7 Sherrardspark Road
Welwyn Garden City AL8 7JW

15 September 2015

Ref: 6/2015/1636/EM

5 Sherrardspark Rd
 WGC
 ALS TJW
 Proposed ~~new~~ extended driveway
 Front elevation.
 31.7.15.

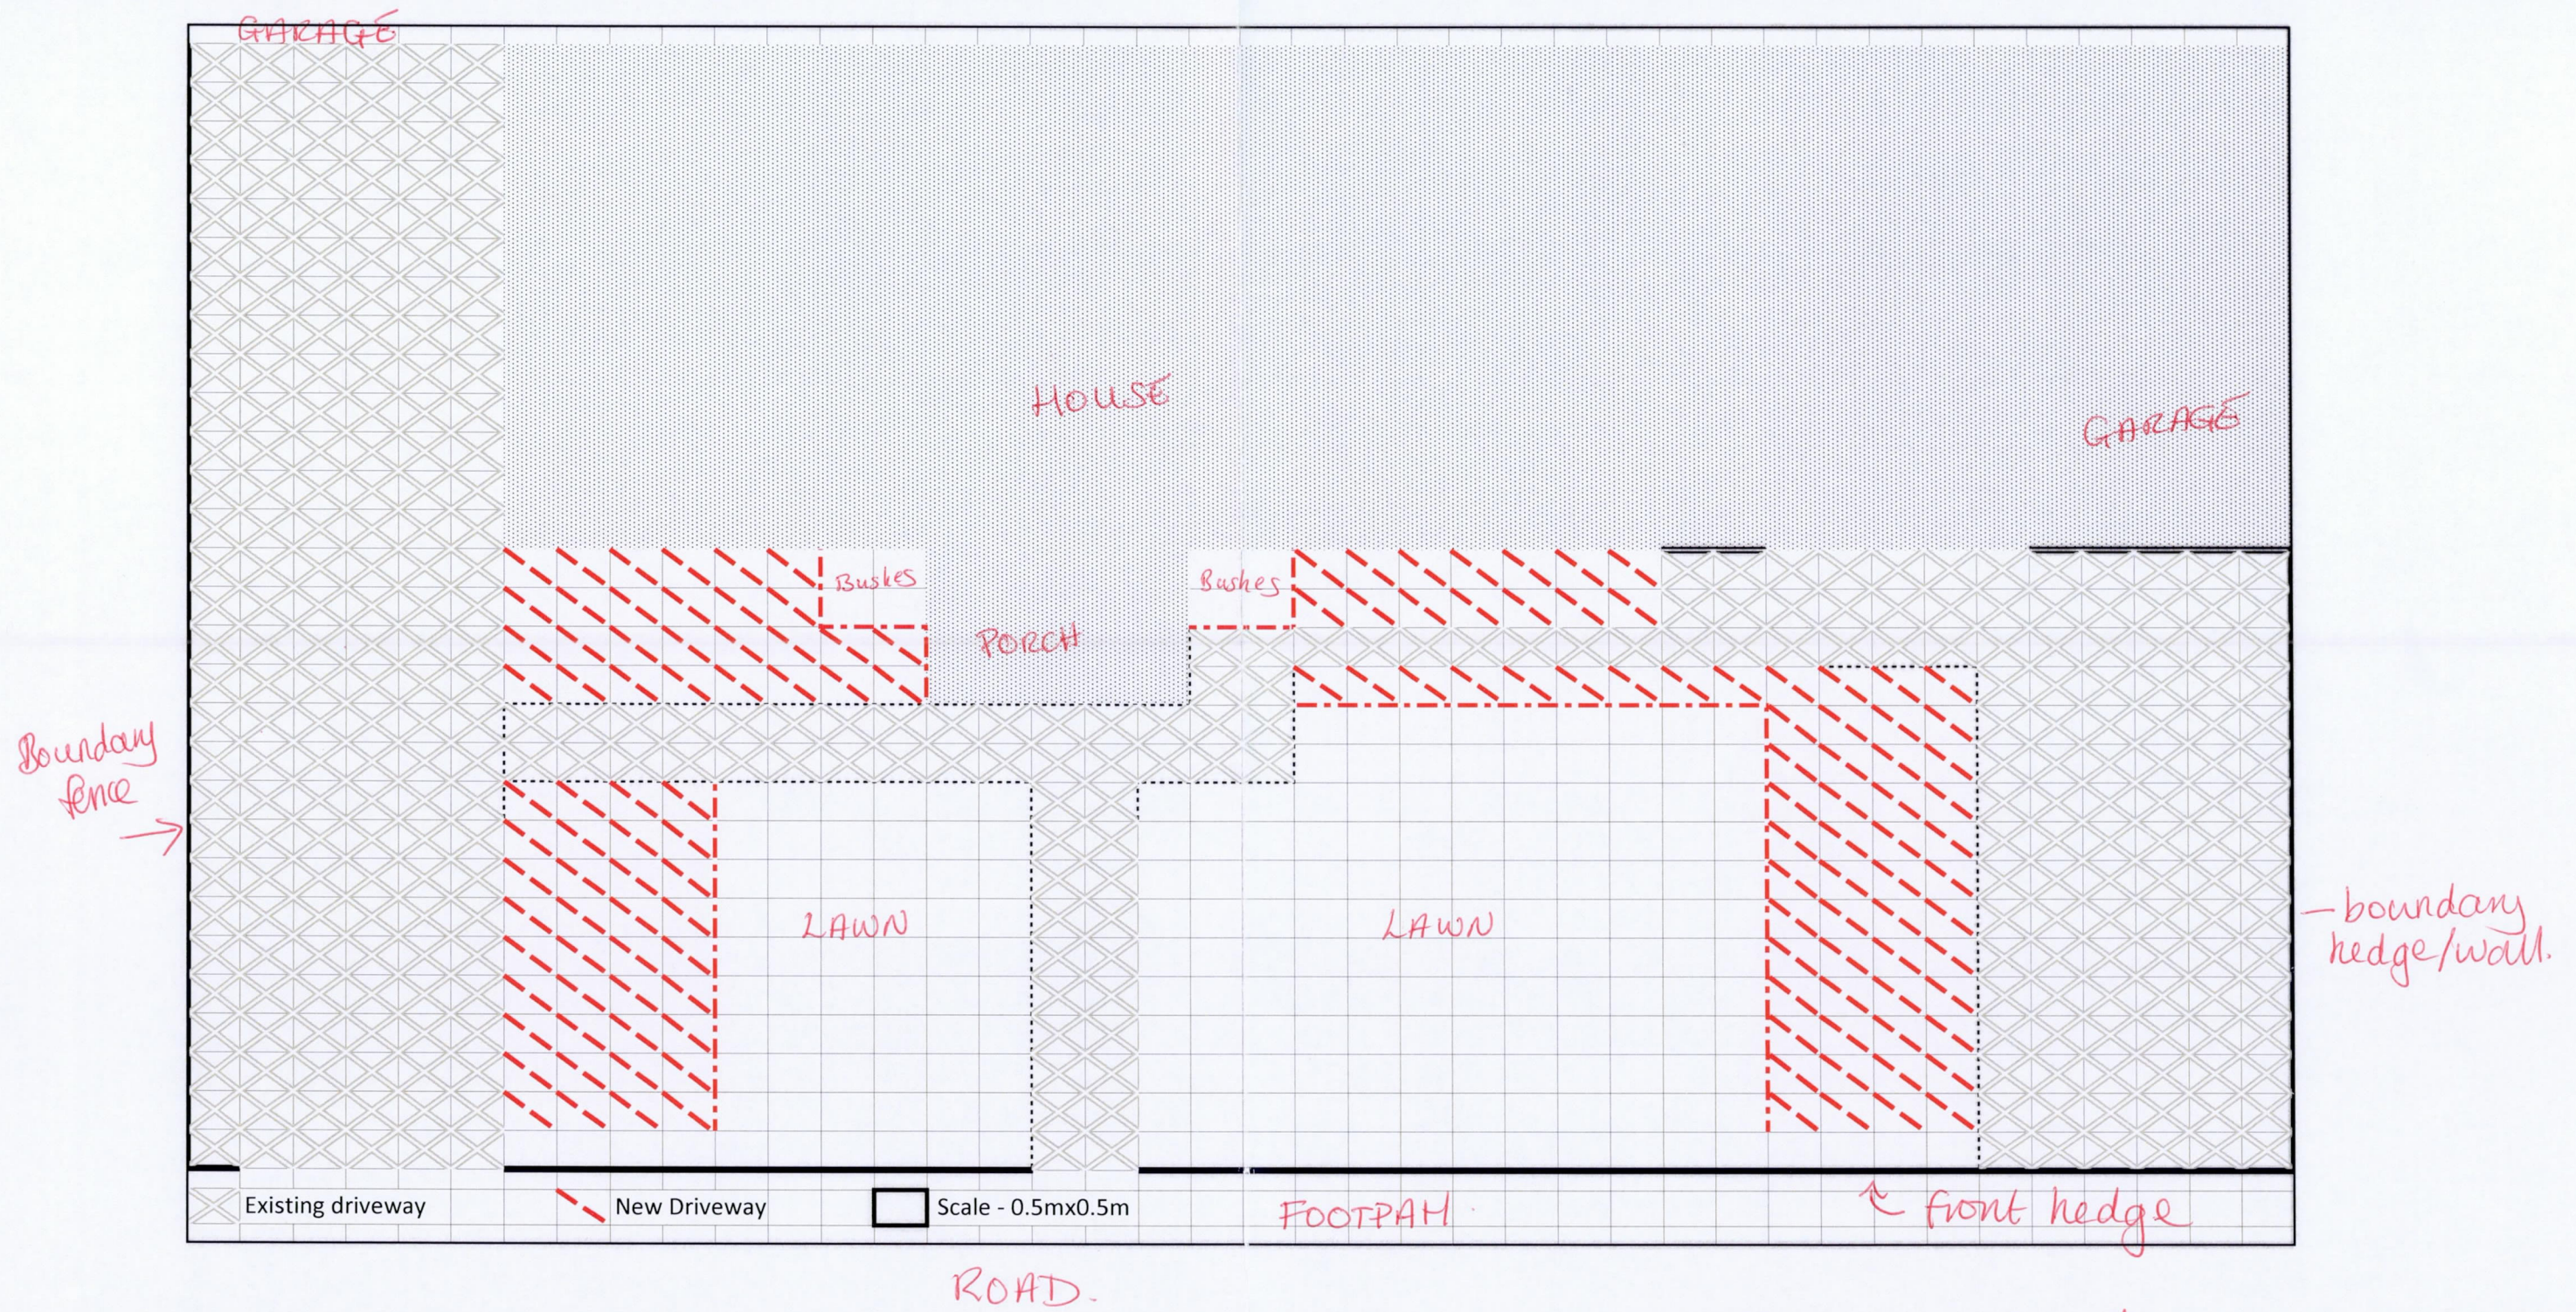
I was surprised at the scale of the additional hard landscaping and the loss of so much grass and borders.

The plan is incorrect, in that it shows the boundary to my property as "boundary hedge/wall". This is misleading. It is in fact a boundary/retaining wall along the boundary of no 5 with the boundary of no 7 (my property) coming forward from the garage on this side which is on the boundary, the hedge which is deciduous is planted on my land and maintained by me.

As I explained, whilst the driveway on this side of the site slopes down from the pavement to the front of the garage at number 5, the land on my side of the boundary is level and so at this point is approximately 3ft higher than the ground immediately in front of no. 5 garage. The entrance to my property is on this side and at this point my path is beside the hedge. You did say you would be doing a site visit and you are welcome to walk up my path so that you can see what I mean.

The application documents you showed me gave no indication of what materials will be used in this work. My concern is that the boundary/retaining wall was probably constructed circa 1930 and without full structural investigation it is difficult to know the depth of footings. I am extremely worried that drilling and digging away the existing concrete slope could de-stabilise the wall, and my hedge, border and path collapse onto the adjoining land.
